**KIRKLEES METROPOLITAN COUNCIL  
INVESTMENT & REGENERATION SERVICE**

**DELEGATED DECISION TO DETERMINE PLANNING APPLICATIONS**

Reference No:	<b>2025/62/93433/W</b>
Site Address:	197, Westgate, Almondbury, Huddersfield, HD5 8XN
Description:	Formation of vehicular access (Listed Building within a Conservation Area)
Recommending Officer:	Joshua Merriman

**DECISION - REFUSED**

DWG. NO.	2517 Rev A	SCALE	As indicated	DATE	05/01/2026
DWG. TITLE	Block Plan and Location Plan				
CLIENT	Mrs Shooter				
PROJECT	Proposed Car Parking Space at 197 Westgate, Almondbury, Huddersfield. HD5 8XN

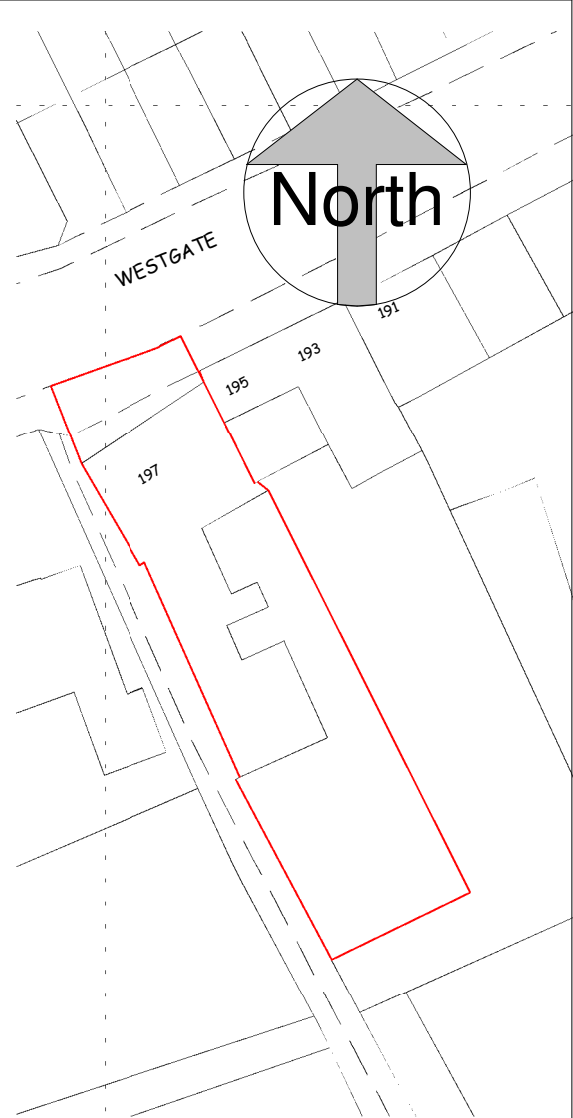
*Whilst the dimensions of the parking space meets the minimum size required, it is at such an angle that it would be difficult to access with a vehicle.*

*There is an existing telegraph pole to one side and the boundary fence of the neighbouring property at the other side. Both of these impede a vehicle accessing the space safely,*

*A public footpath emerges onto Westgate at this location and would be obstructed by a vehicle parked in this area I would consider that, in practice, a vehicle parked on the footway in this location would both overhang the adopted footway and obstruct the public footpath to the detriment of the safety of pedestrians using both the footway and public footpath.*

*Furthermore, the land on which the parking space is proposed is not within the curtilage of the application property, and lies upon an adopted footway.*

The parking space proposed, due to the size and location, being restricted by an existing telegraph pole and fence, proximity to the adopted footway and public right of way, would be difficult to safely manoeuvring and access to and from it would be compromised to the detriment of pedestrian and vehicle safety contrary to Policies LP21 and LP22 of the Kirklees Local Plan, and Chapter 9 of the National Planning Policy Framework.
